Immingham Green Energy Terminal

9.3 Applicant's Responses to the Examining Authority's First
Written Questions

(Responses to "Q1.1. General and Cross-cutting")

Document Reference: TR030008/EXAM/9.3

AECOM

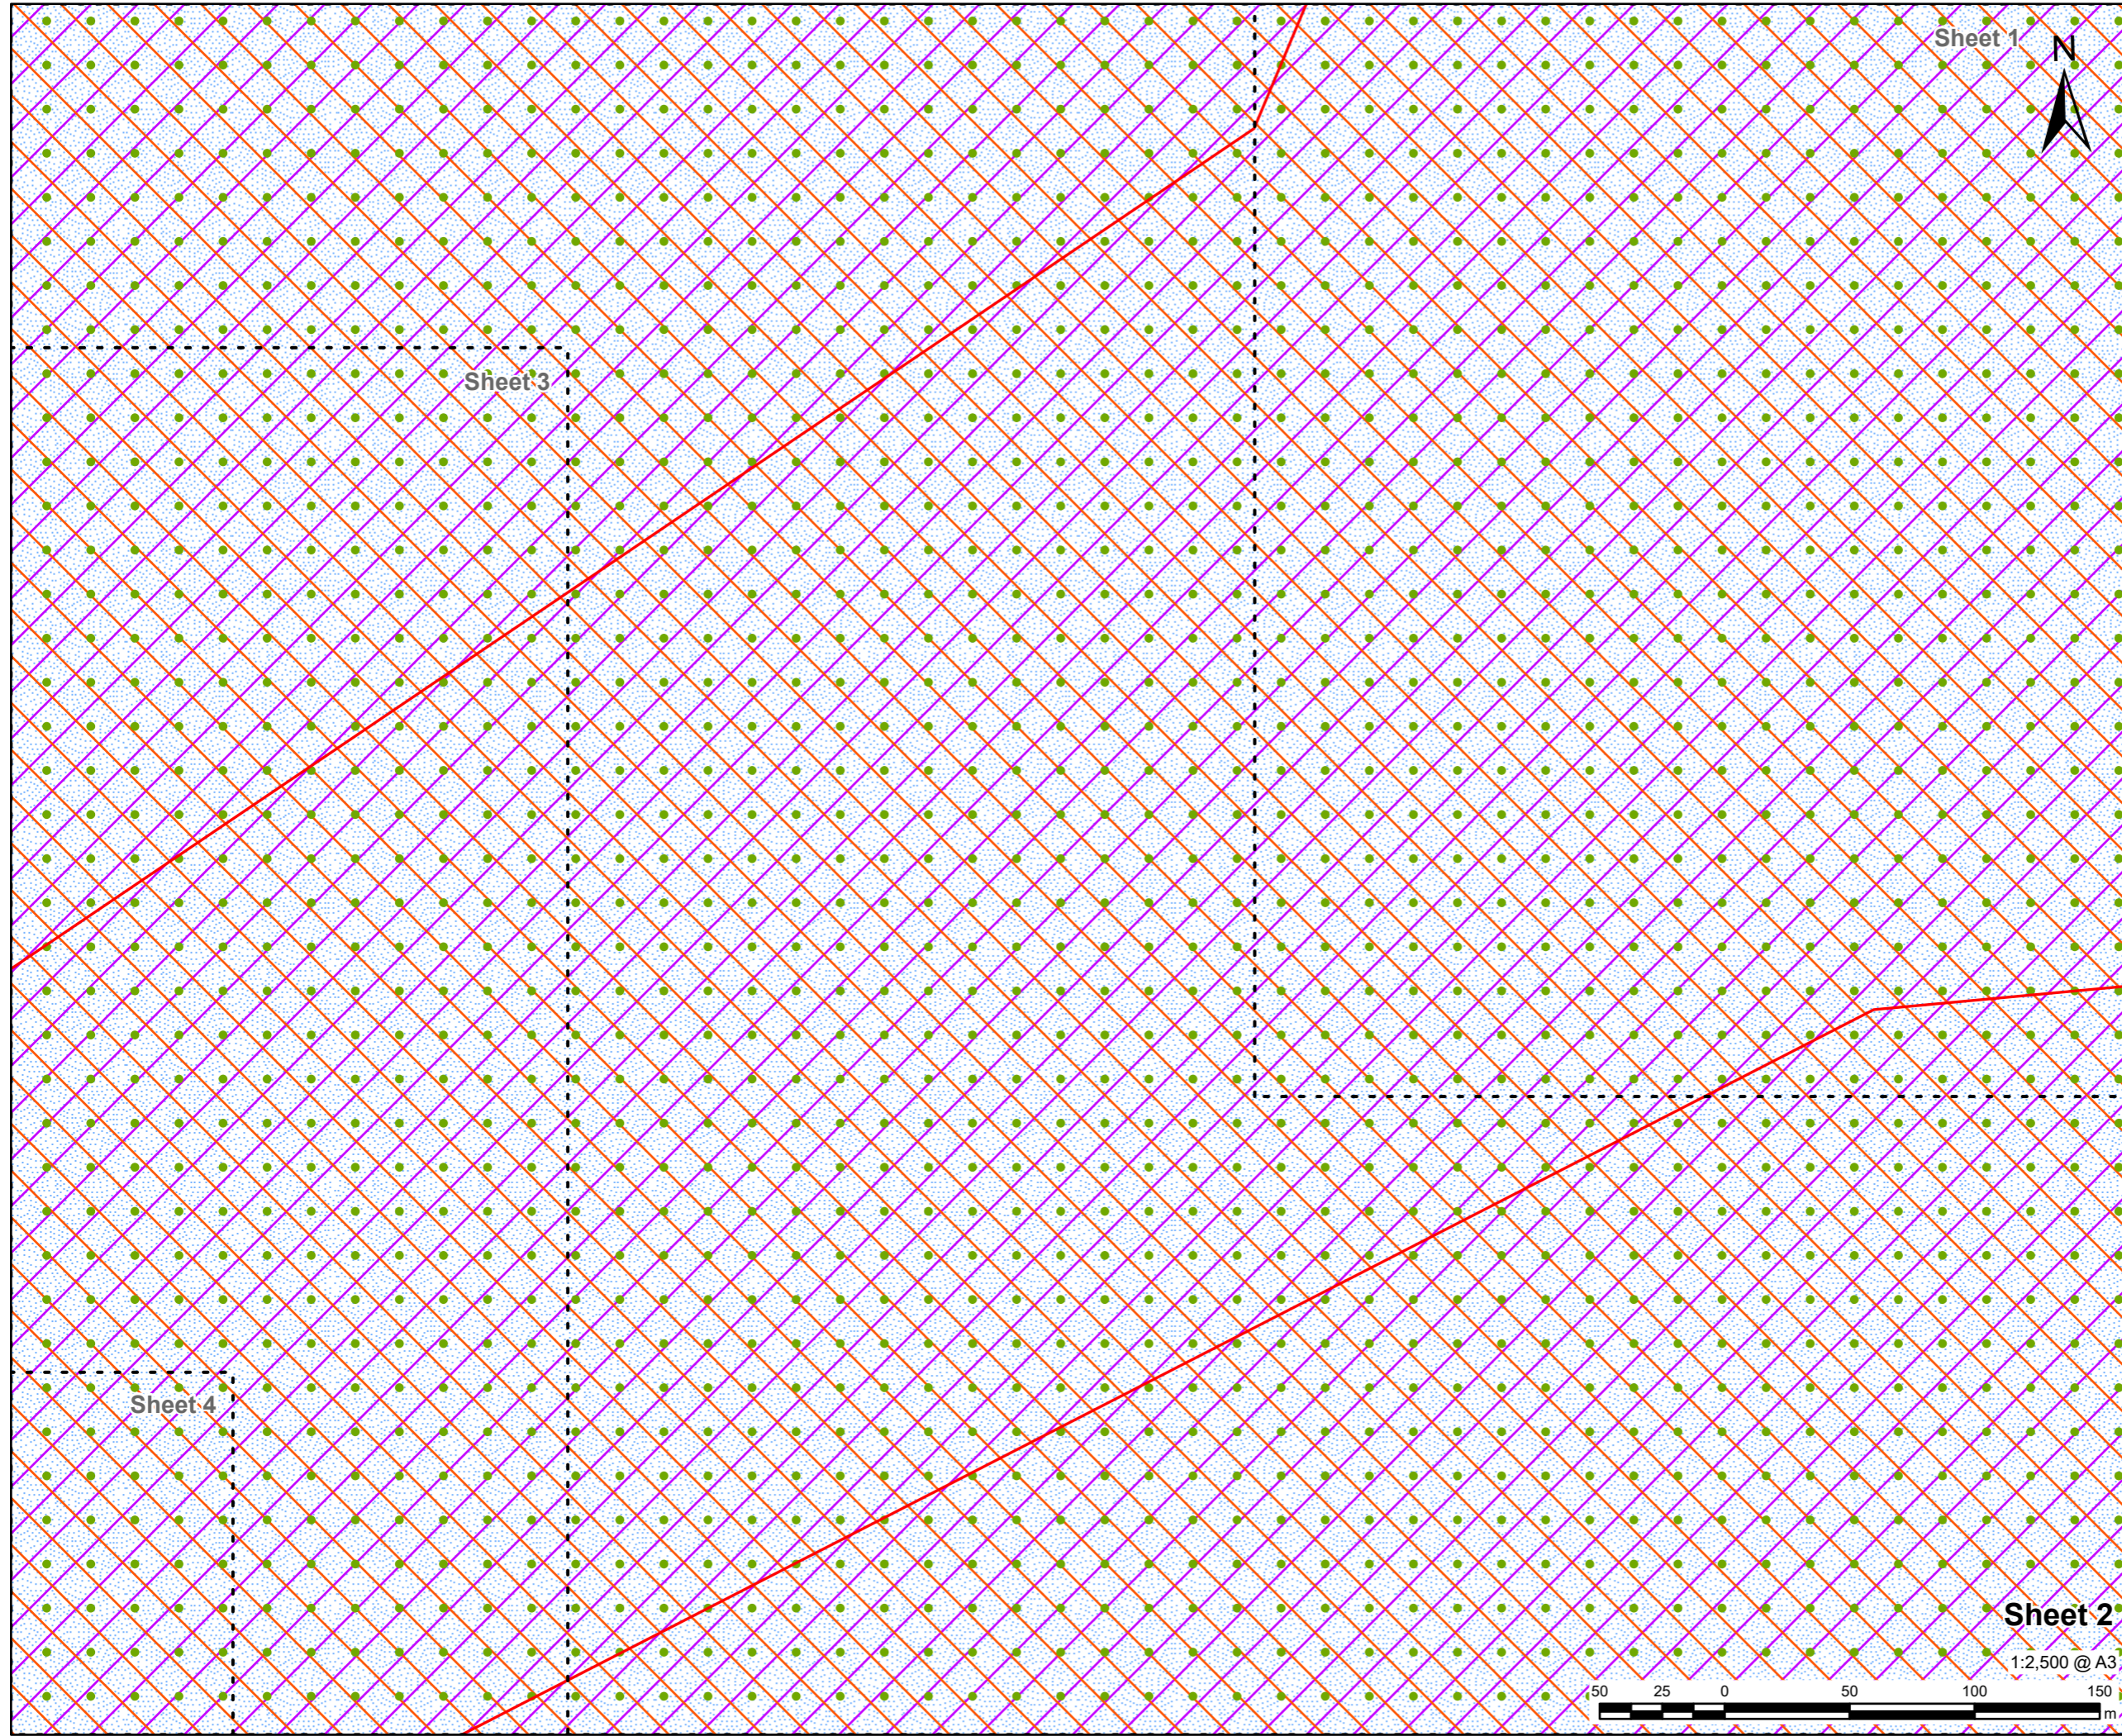
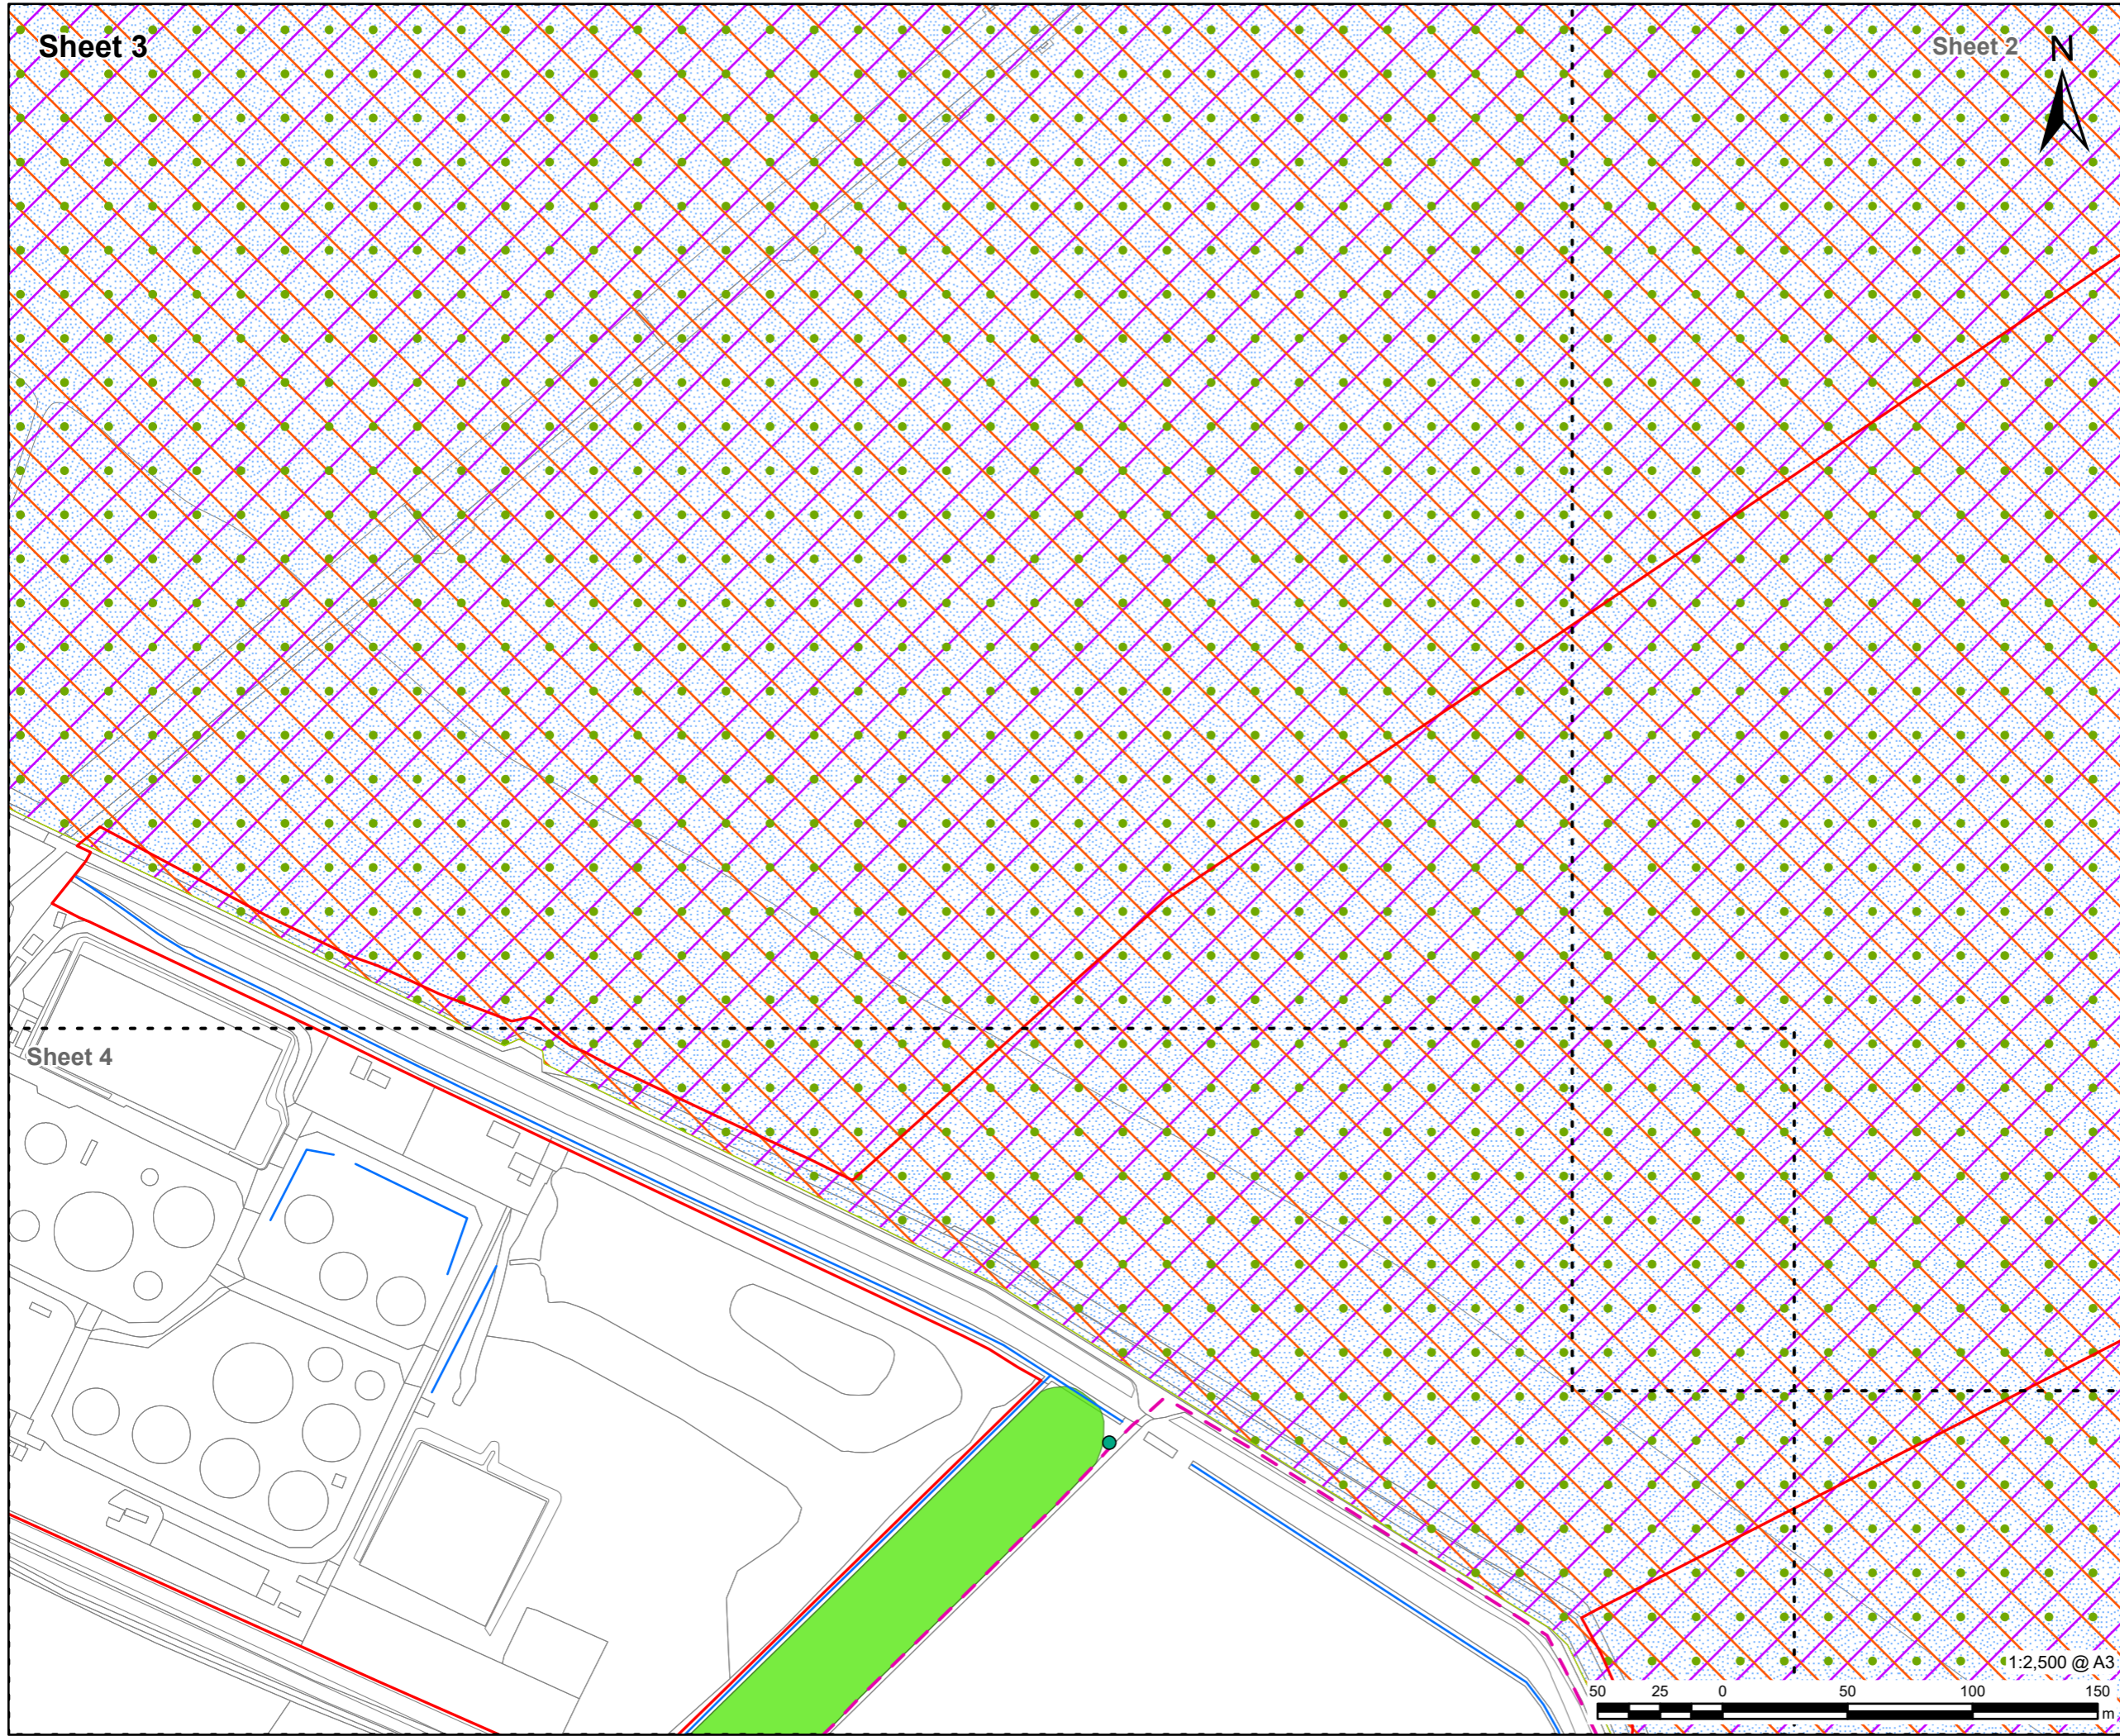
<p>Document Correction</p> <p>ES [APP-181, Appendix 8.B, Paragraph 2.3.14] states that the Long Strip south of Laporte Road is not included in the site boundary. However, it is included on all the site maps. Explain or clarify or correct this document.</p>	<p>The Long Strip south of Laporte Road is included in the Site Boundary. Paragraph 2.3.14 within ES Appendix 8.B: Preliminary Ecological Appraisal Report [APP-181] should state:</p> <p><i>“A narrow band of woodland approximately 40m in width located on the north side of Laporte Road; the same woodland band also continues south from Laporte Road and is essentially split into two halves by the road. Both sections of woodland are within the Site Boundary.”</i></p> <p>The Table of Errata [PDA-010] submitted at Procedural Deadline A also provides the corrected text.</p>
<p>Q1.1.1.4</p>	
<p>Question</p>	<p>Response</p>
<p>Transboundary</p> <p>Considering all aspects of the Proposed Development, would there be any issue which may affect transboundary matters or foreign countries? If so, what would be the magnitude of these impacts, and would these be adverse in nature?</p>	<p>The Planning Inspectorate undertook a transboundary screening for the purposes of Regulation 32 of the Infrastructure Planning (Environmental Impact Assessment) Regulations 2017 on 2 March 2023 following the Applicant's request for a Scoping Opinion.</p> <p>The Planning Inspectorate concluded that the Project is likely to have a significant effect on the environment in a European Economic Area (“EEA”) state, and subsequently Denmark and Iceland were notified of the Project. The reason for notification related to the potential impacts on bird populations of conservation importance.</p> <p>The Planning Inspectorate published a second Transboundary Screening on 1 February 2024, concluding that no new EEA states had been identified as being likely to have significant effects on their environment. On a precautionary basis, Iceland would be notified of the Project and Denmark would be consulted as they had requested to be involved in the transboundary consultation.</p>
